DRAWING TITLE
PHASE 4C - SITE SETUP PLAN

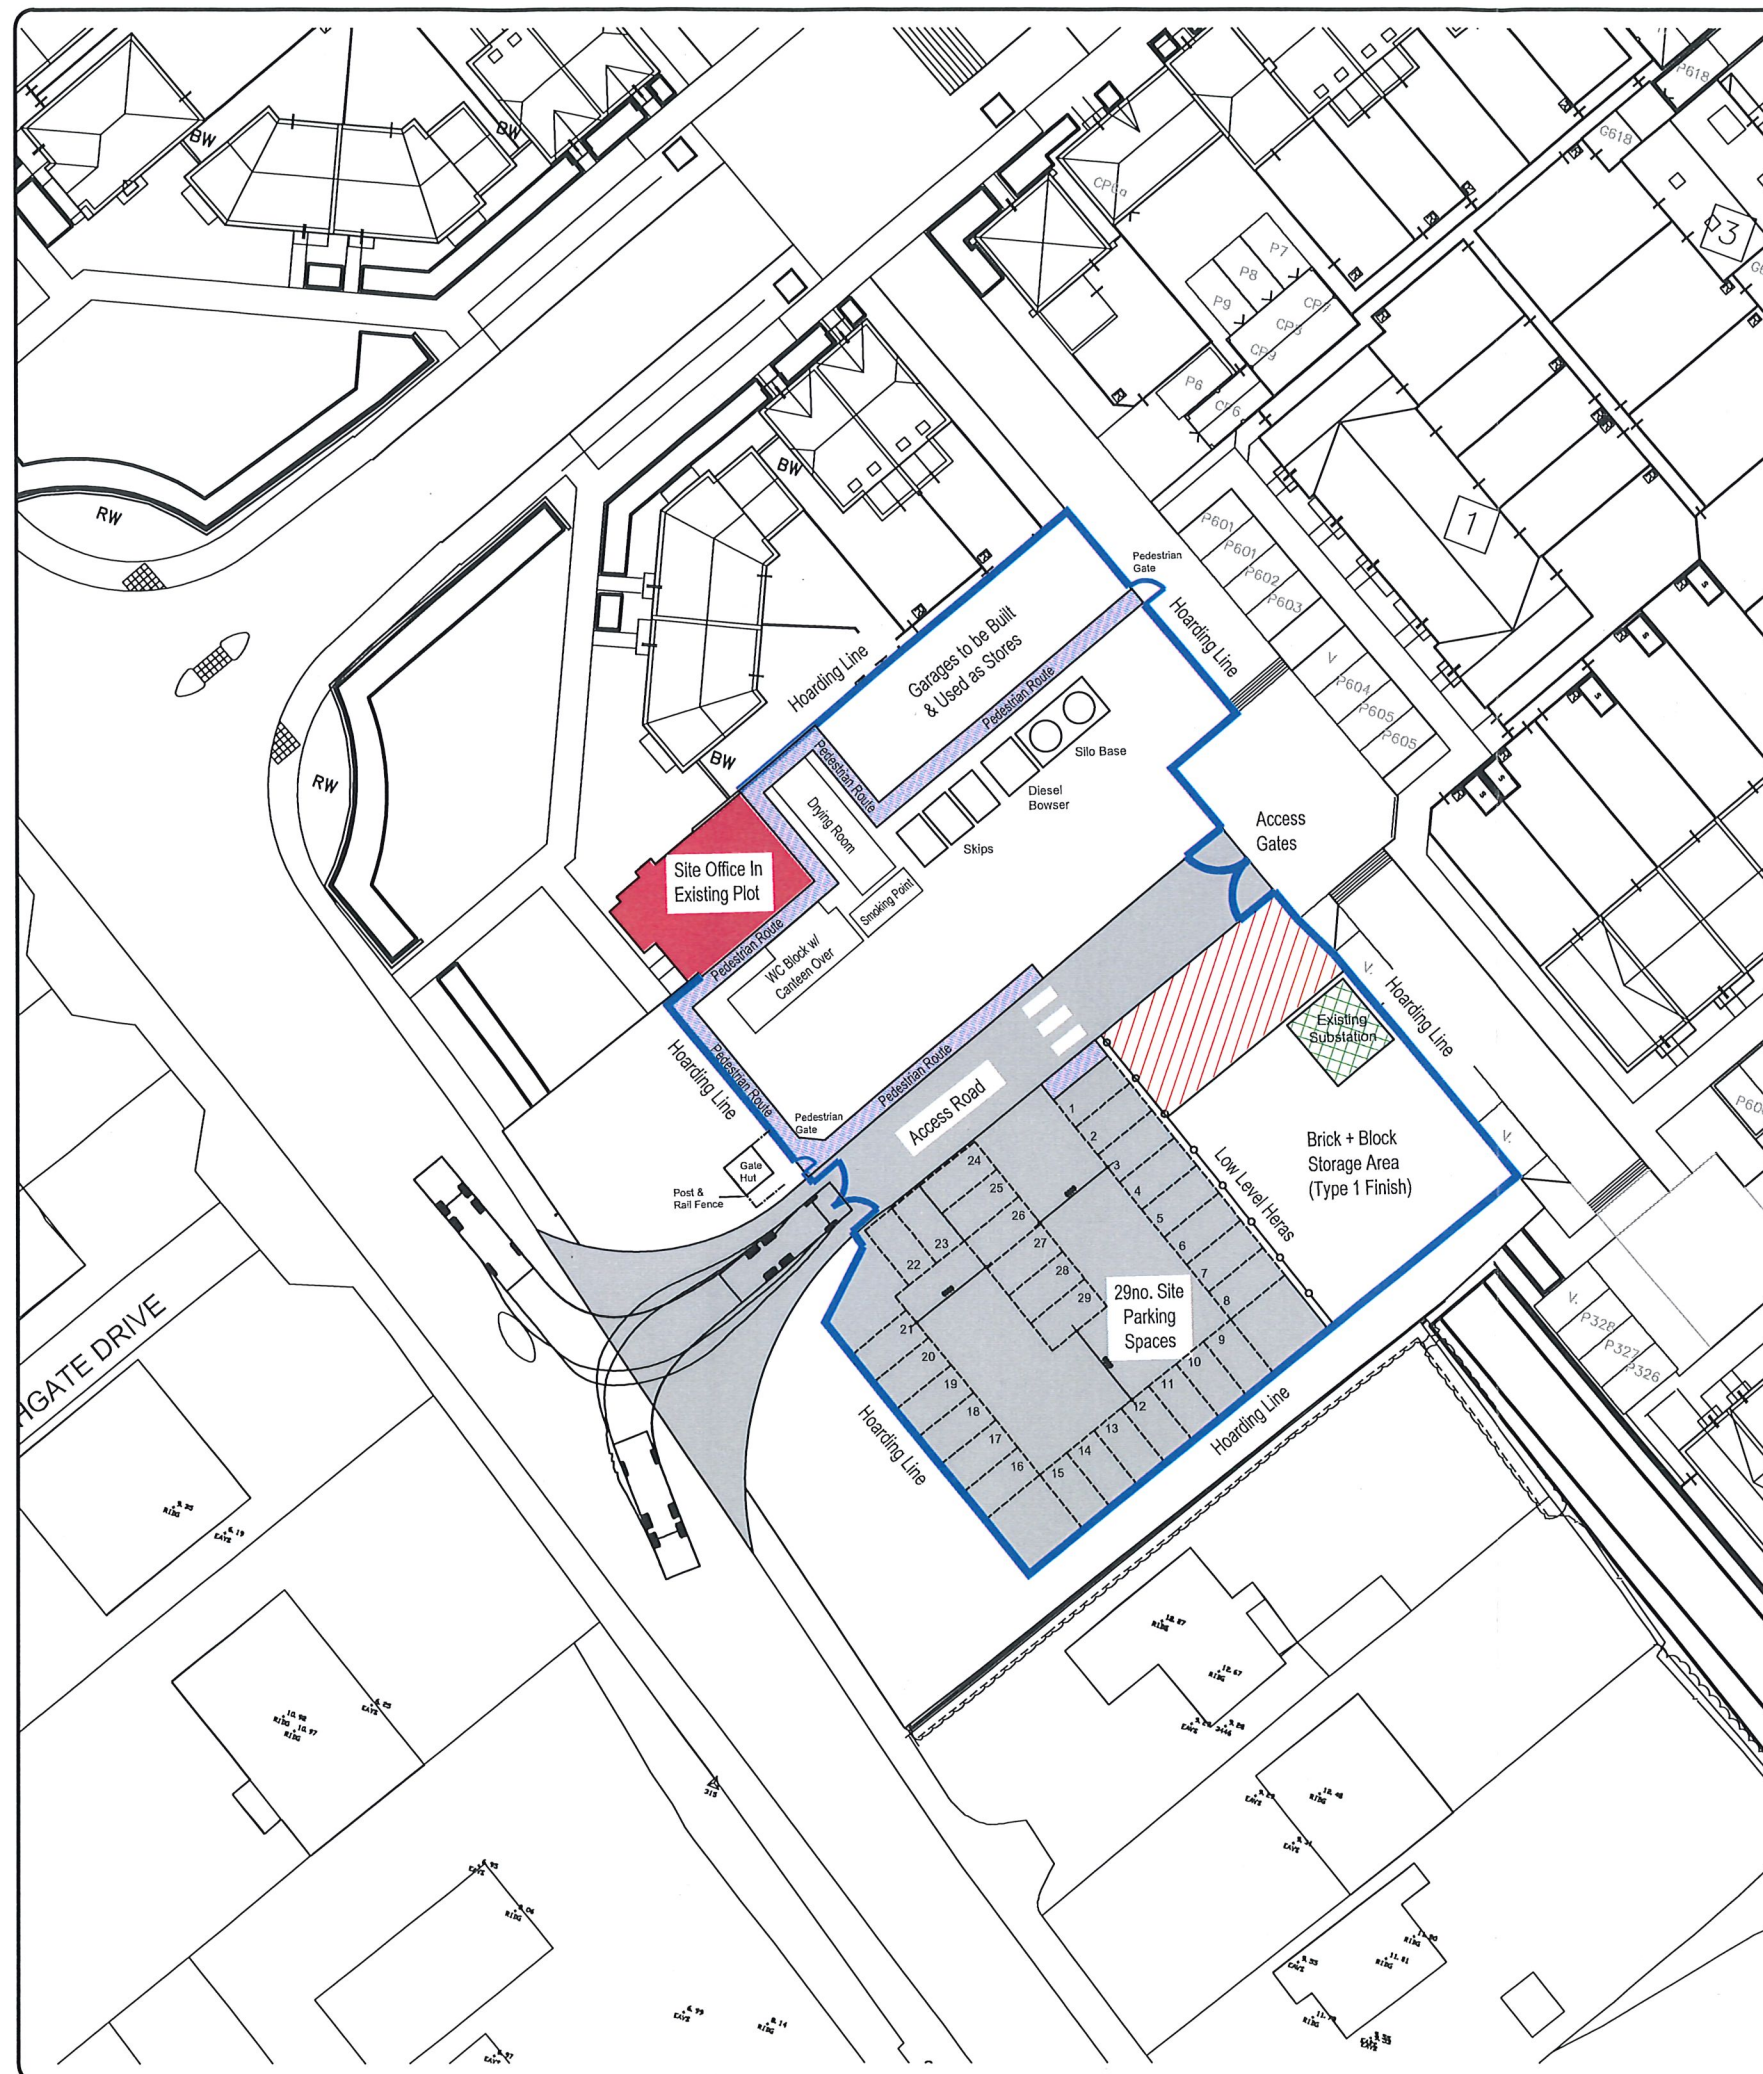
1. Clear demonstration of areas for parking of contractors There are 29no. parking spaces shown on the plan.
2. Loading and unloading area There is a red hatched area on plan shown for vehicle reversing/unloading area.
3. Demonstration of turning on site There is an in and out system in place, two access points are shown clearly on the plan.
4. Areas for storage of materials Areas for storage of materials are clearly shown on plan.
5. Wheel washing facility All site compounds have wheel washing facilities, this would be no different to previously approved on this site.

‘I note the lorry turning point but it has not been demonstrated that lorries can turn within this space to exit the public highway in a forward gear. Furthermore, wheel washing has not been indicated and the turn in to the site appears to take place from opposite side of carriageway. Please could you ask the applicant to show the swept path tracking properly including the turn within the site and indicate wheel wash location.’
